Town & Country Planning Act 1990 (as amended)
Town & country Planning (Development Management Procedure) (England) Order 2015
Application for Planning Permission for Works or Extension to a Dwelling

Development Single storey rear extension, single storey front/side infill extension & removal of entrance porch at front.

Location 98 Elmer Road Middleton on Sea

Block Plan Amend

Ground Floor Plan ~ As Proposed

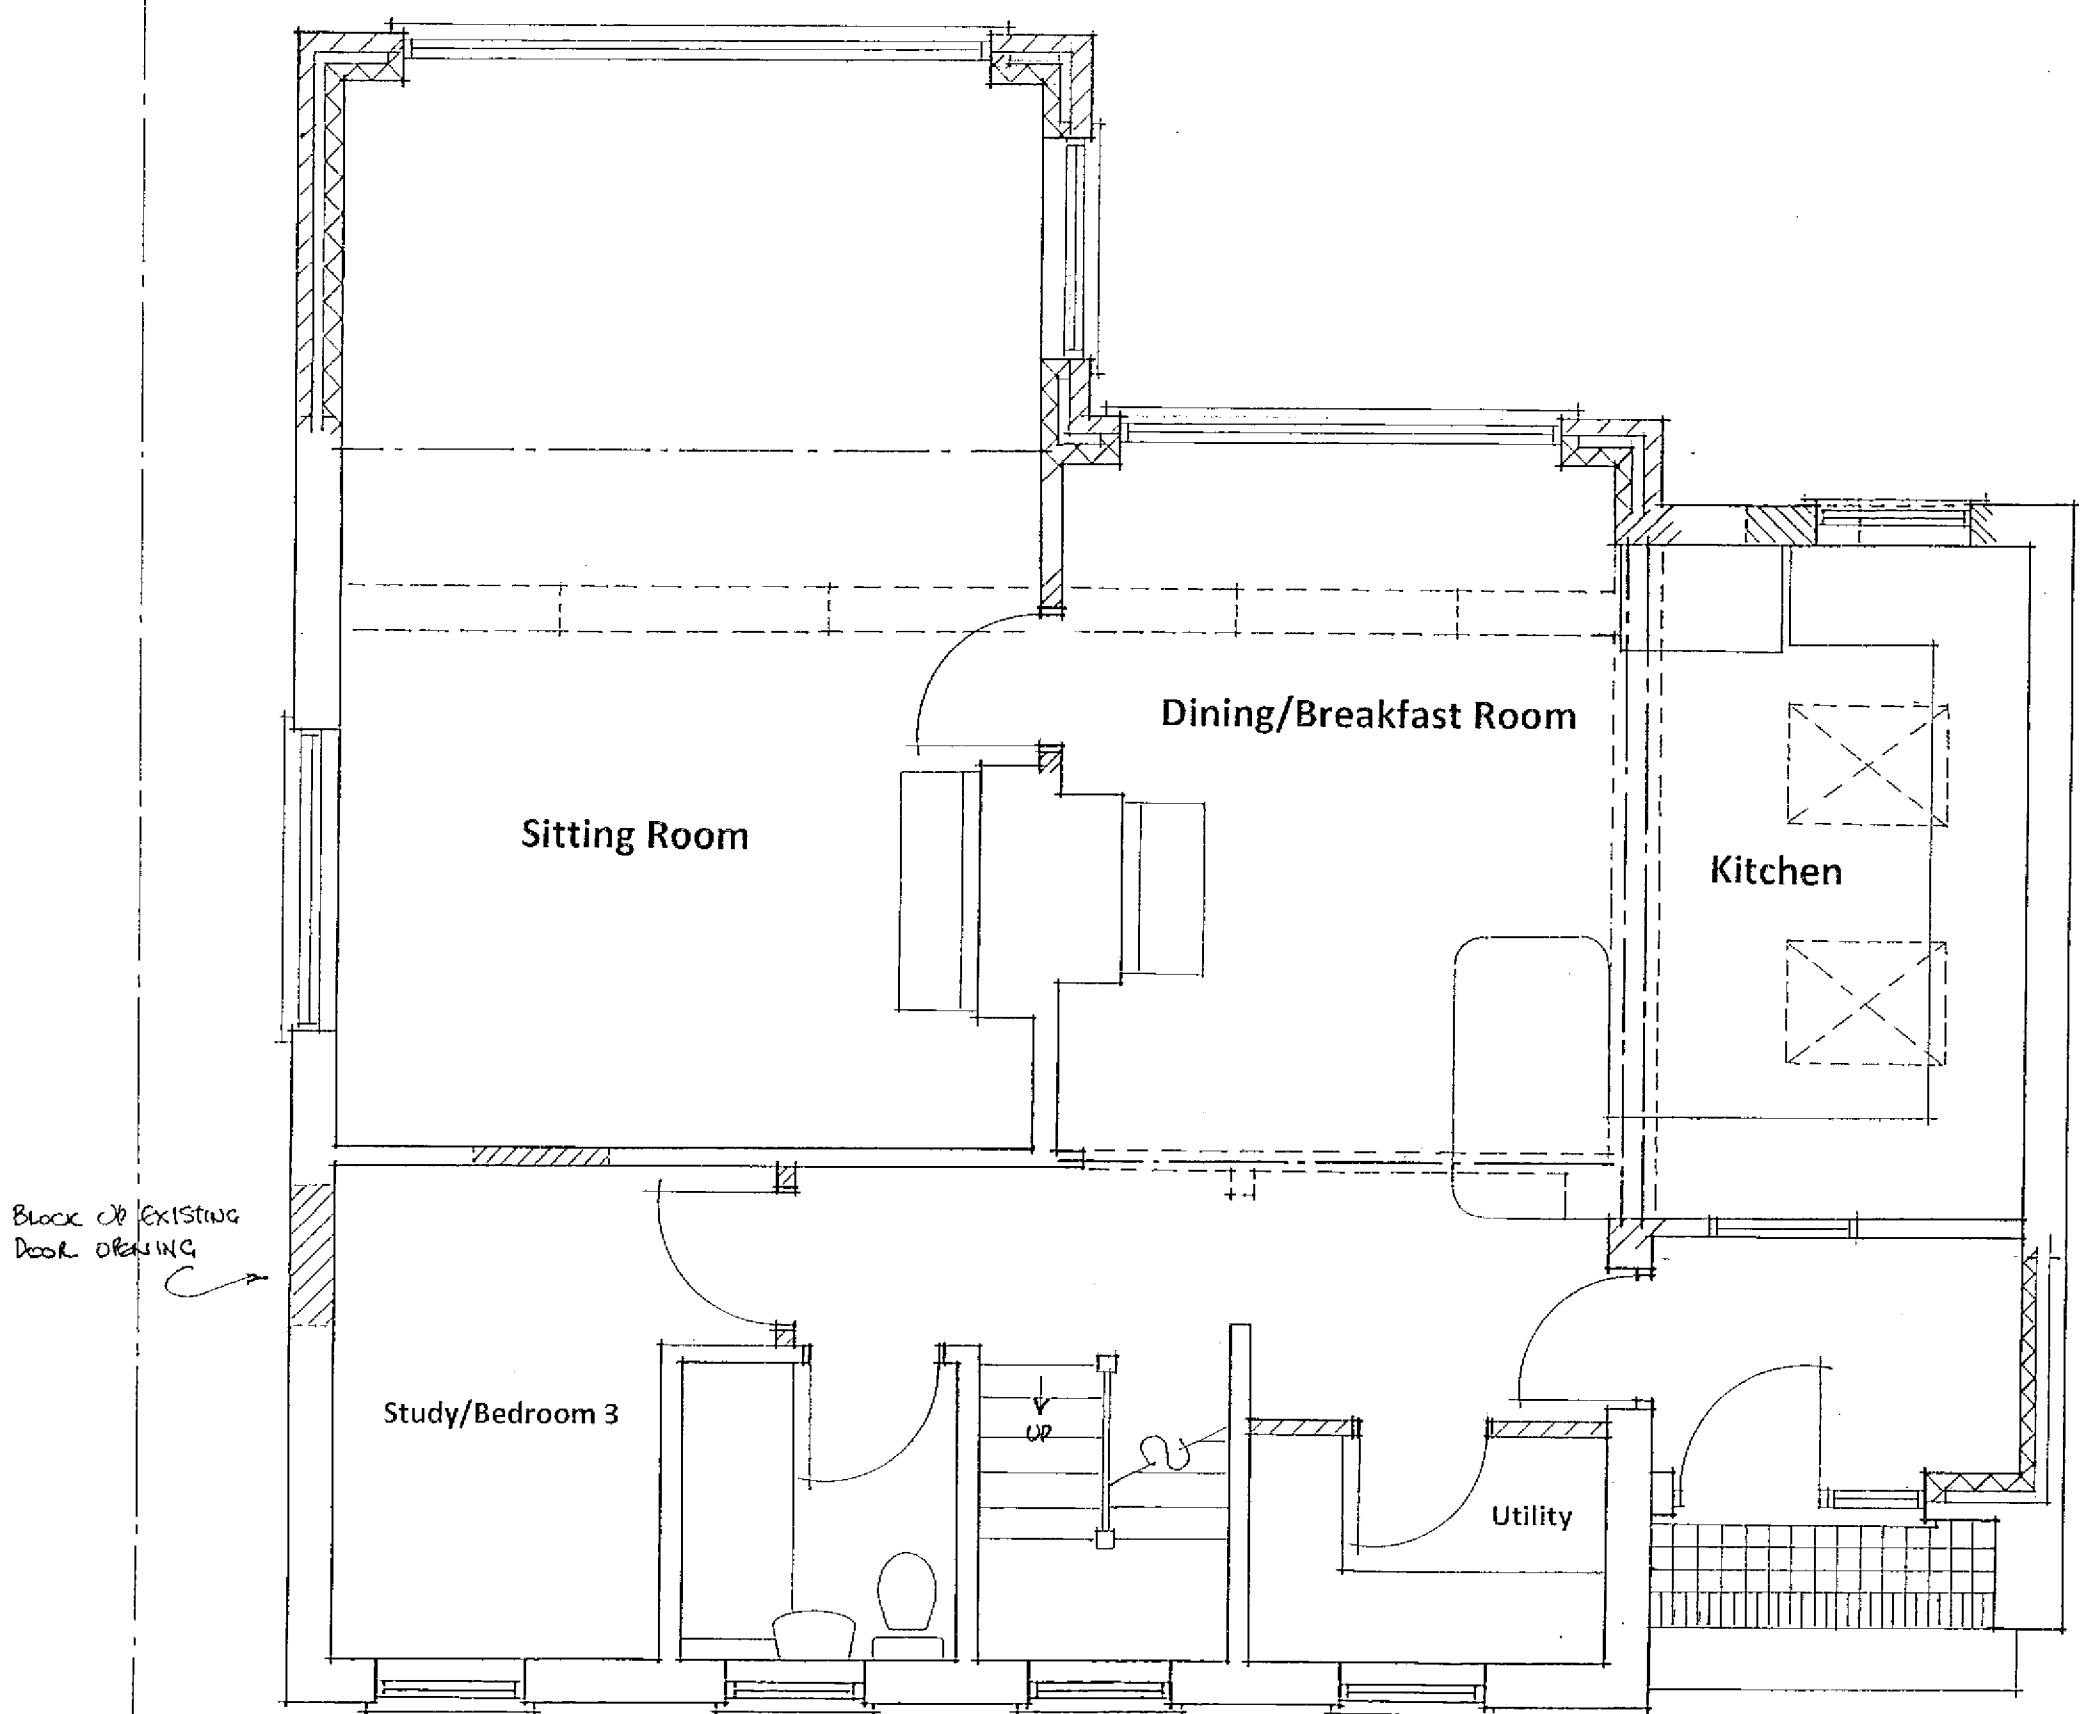
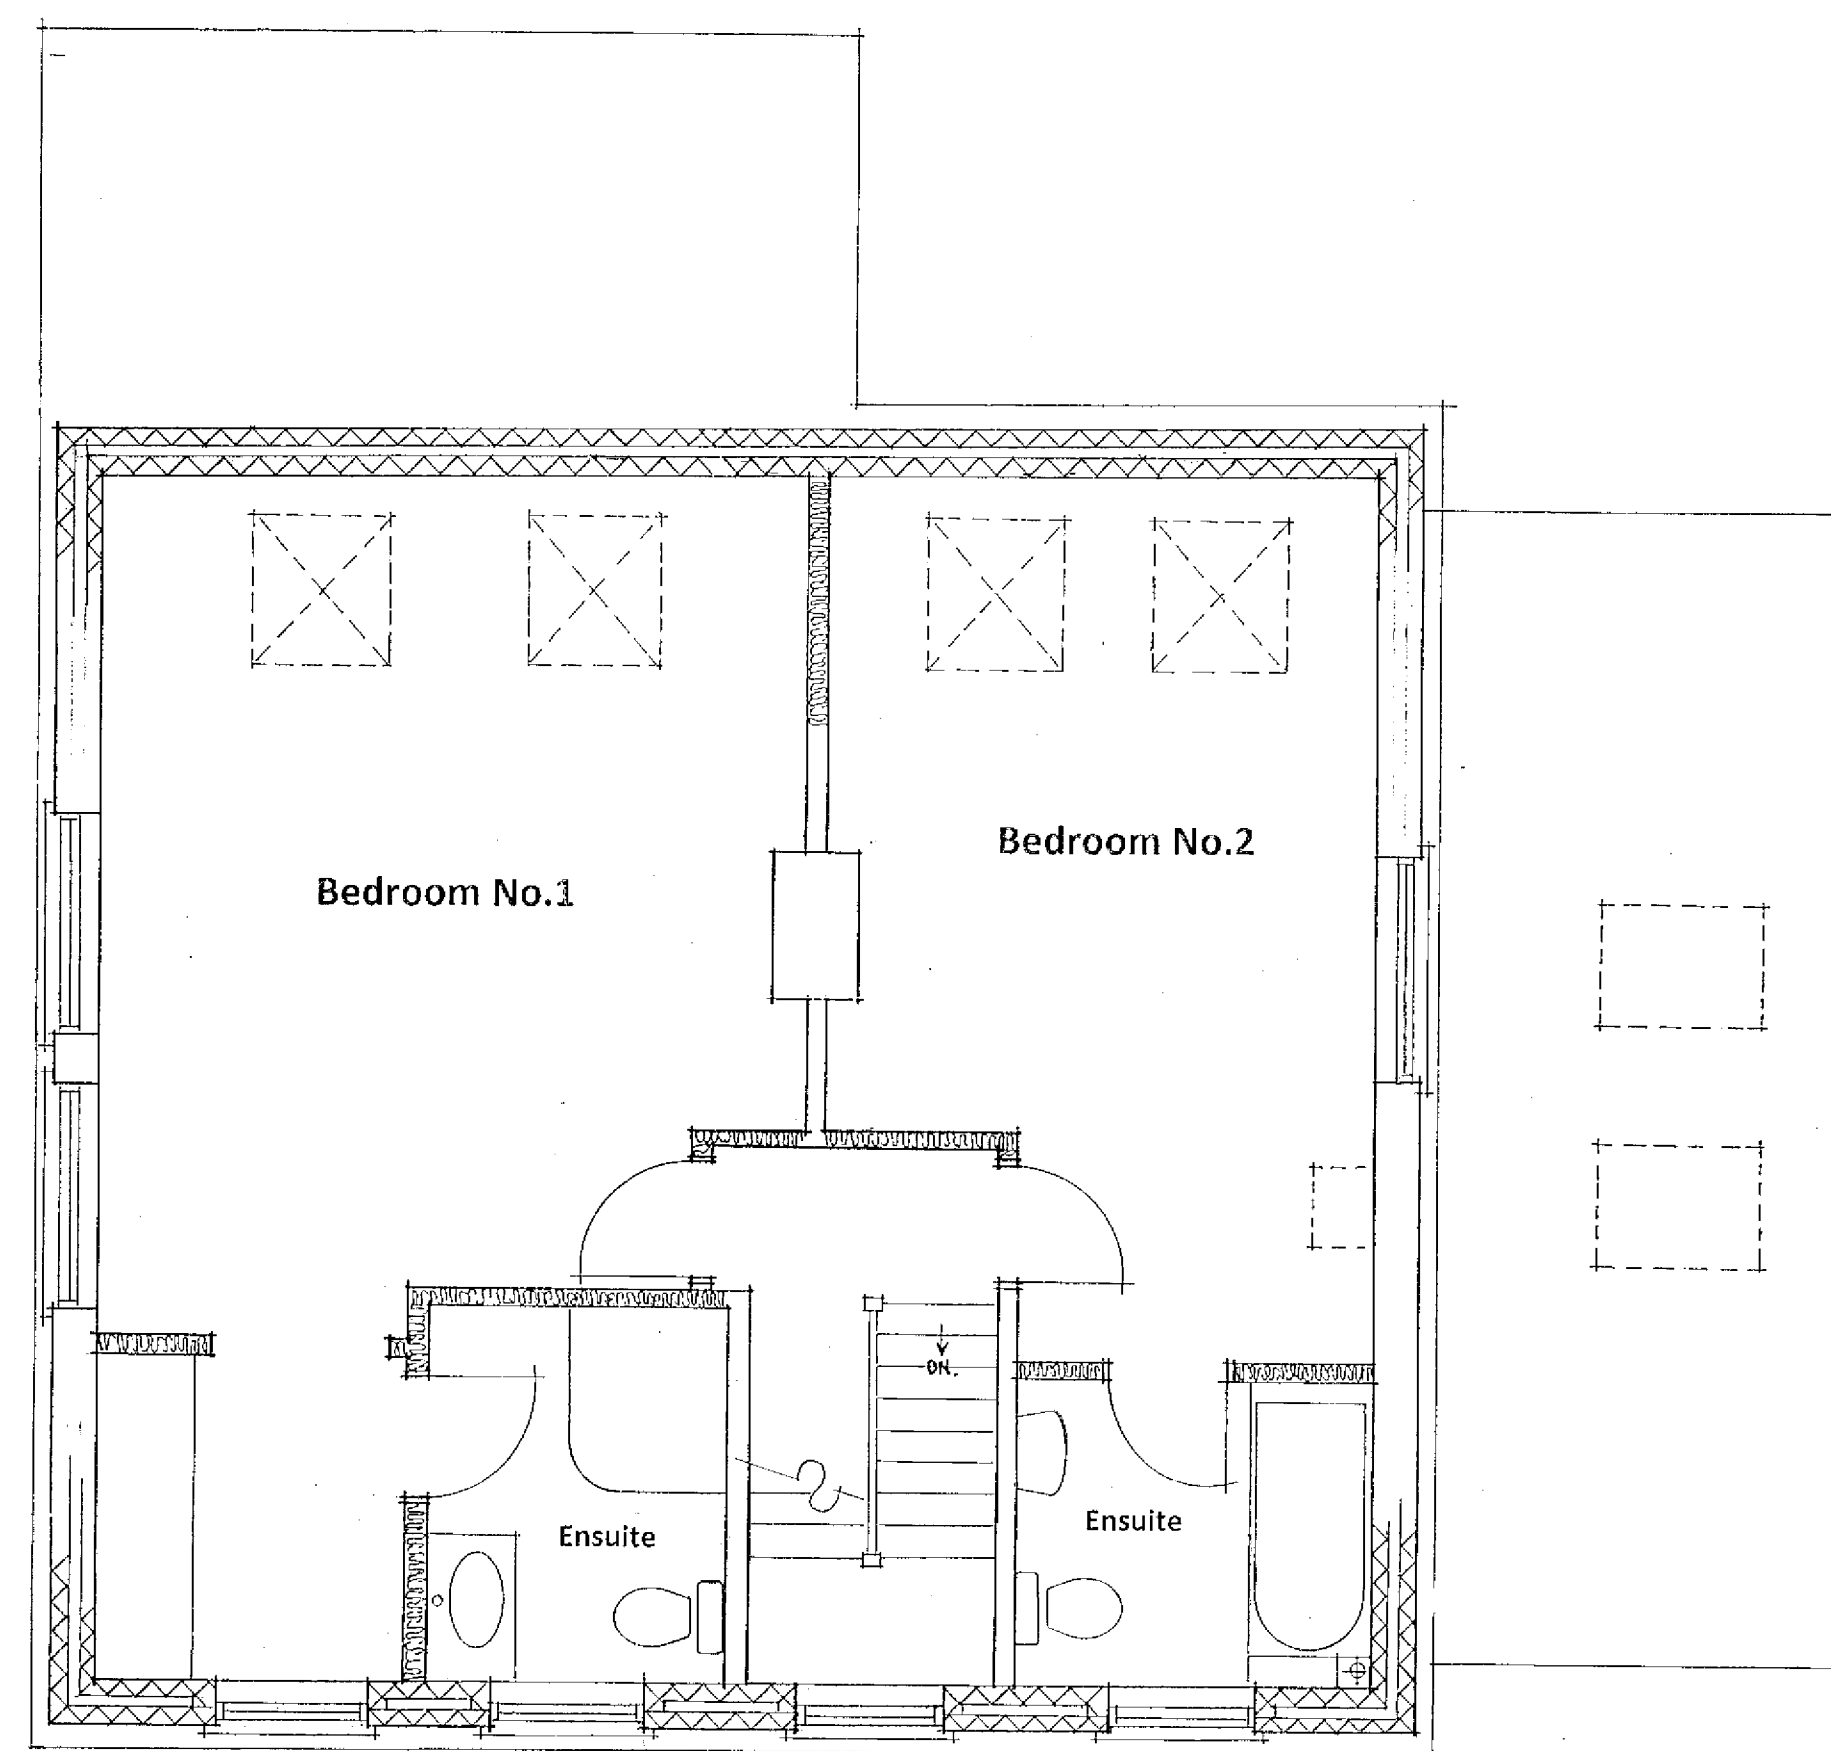
The proposed front ground/first floor plan and front elevation do not accord. Please amend accordingly.
